East Anglia One North (EA1N) and East Anglia Two (EA2) Offshore Wind Farms

**Planning Inspectorate Reference: EA1N – EN010077 &
EA2 – EN010078**

Deadline 6 - 24 February 2021

**ESC Comments in Response to the Applicants
Deadline 5 Submissions**

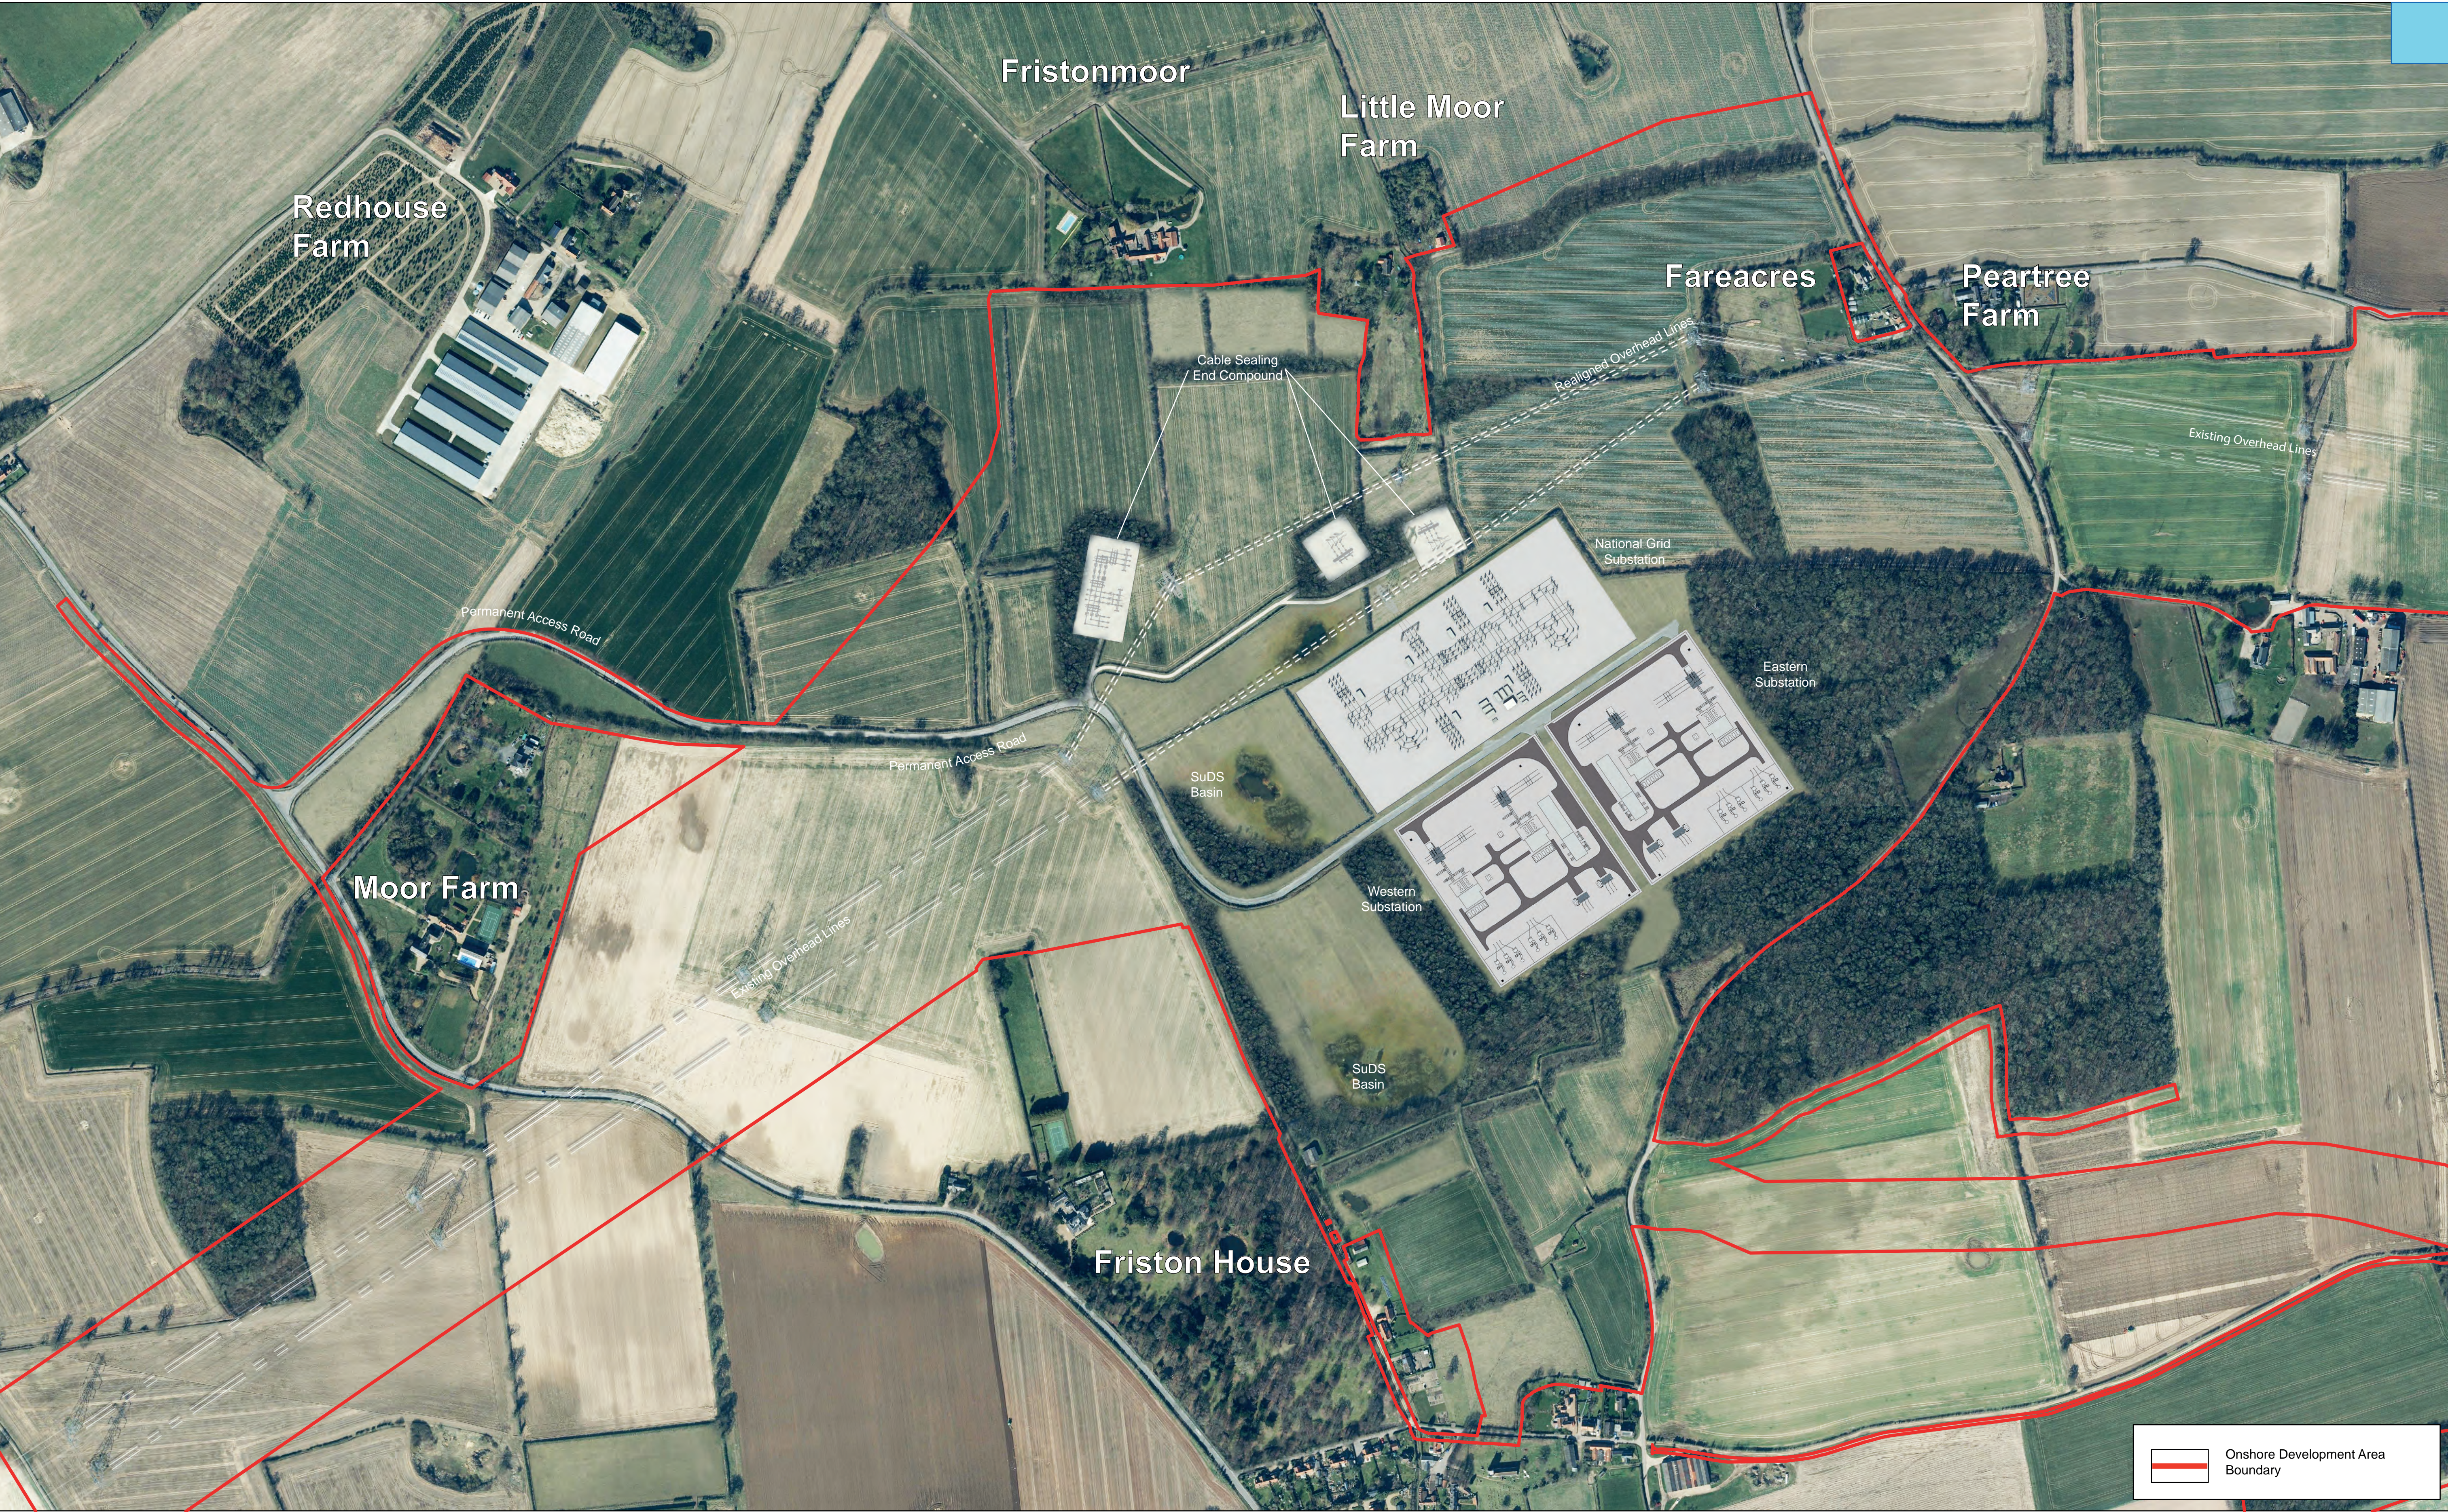
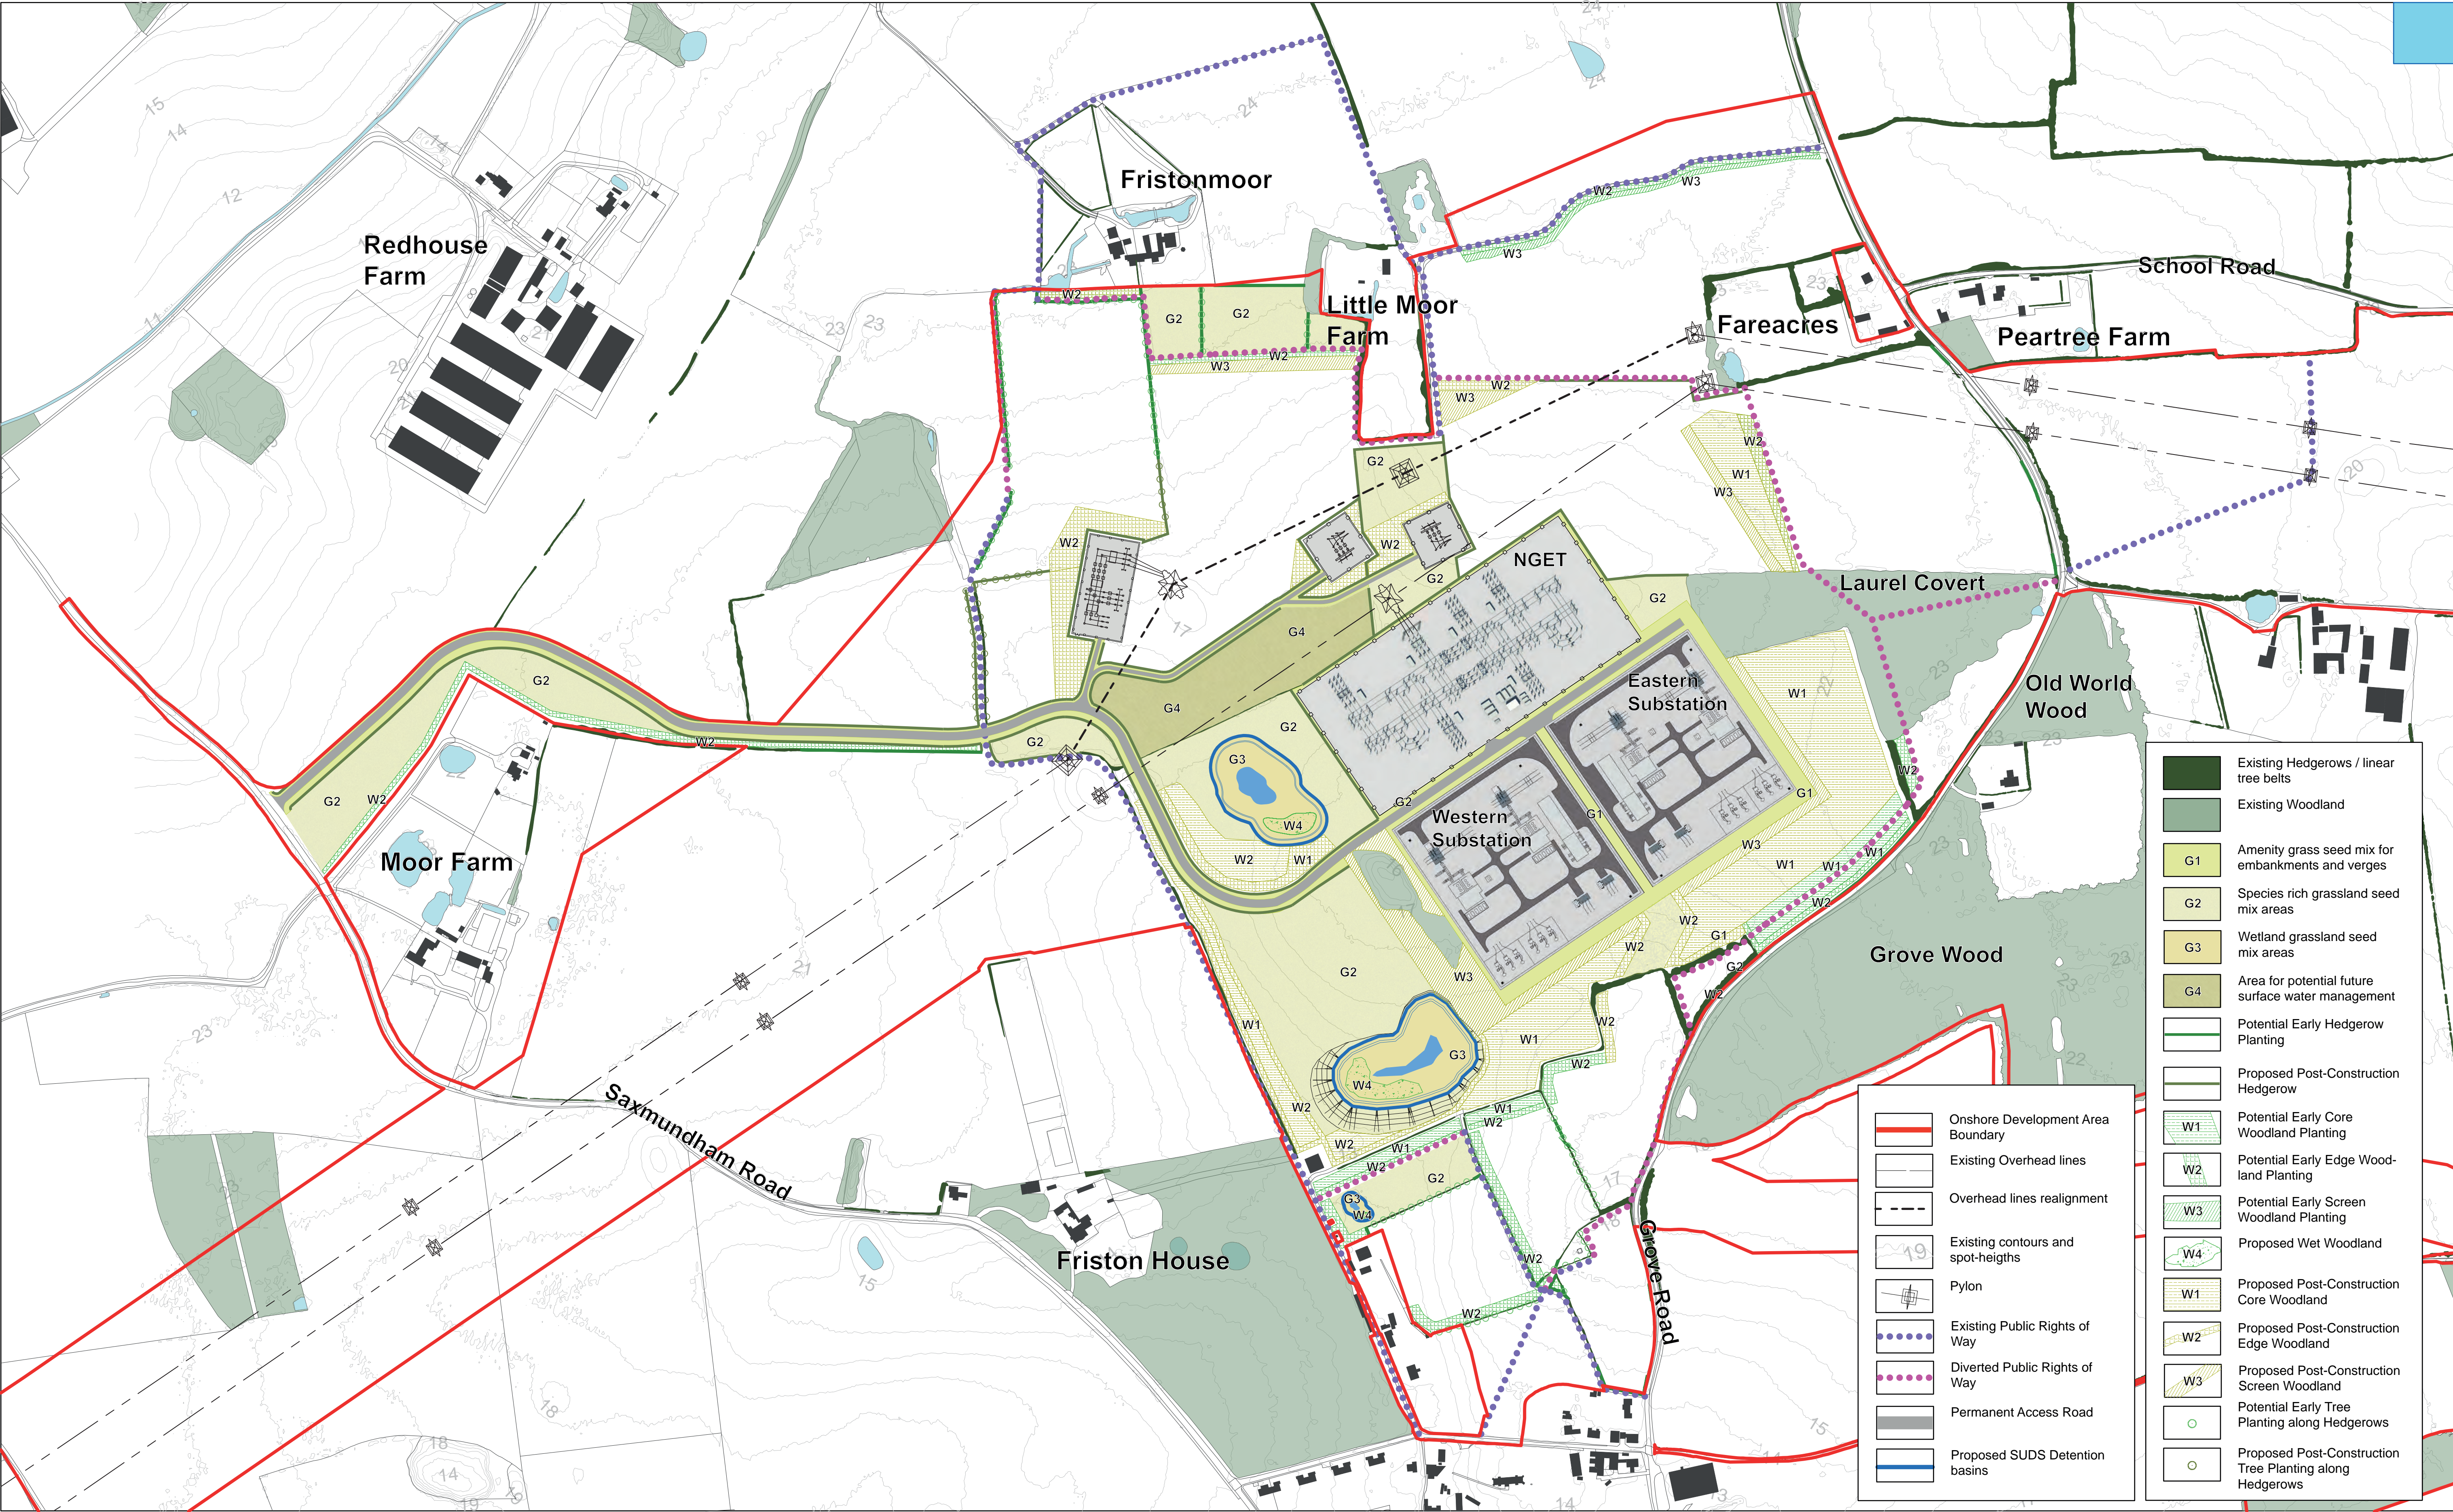
Applicant’s Comments on ESC’s Deadline 2 Submissions (REP5-010)			
<i>Ecological Enhancement Clarification Note (REP1-035)</i>			
9	Table 3 – This table states that 85.59km of new hedgerow planting will be provided at the substations. This figure appears excessive as the Outline Landscape Mitigation Plan (OLMP) General Arrangement drawing (ref. 29.11a) only appears to show approximately 5km of new hedgerow planting. Further clarification in relation to this matter is required.	The Applicants have identified that the existing hedgerow length at the onshore substation locations is 3.68km. The calculations in the Ecological Enhancement Clarification Note (REP1-035) assume that 3.68km will be removed as a result of construction of the Projects. The Applicants note that there is likely to be a calculation error in the length of newly planted hedgerow at the onshore substation location. This will be reviewed, and an update provided at Deadline 6.	Noted. We will provide further comment when the updated information is available.
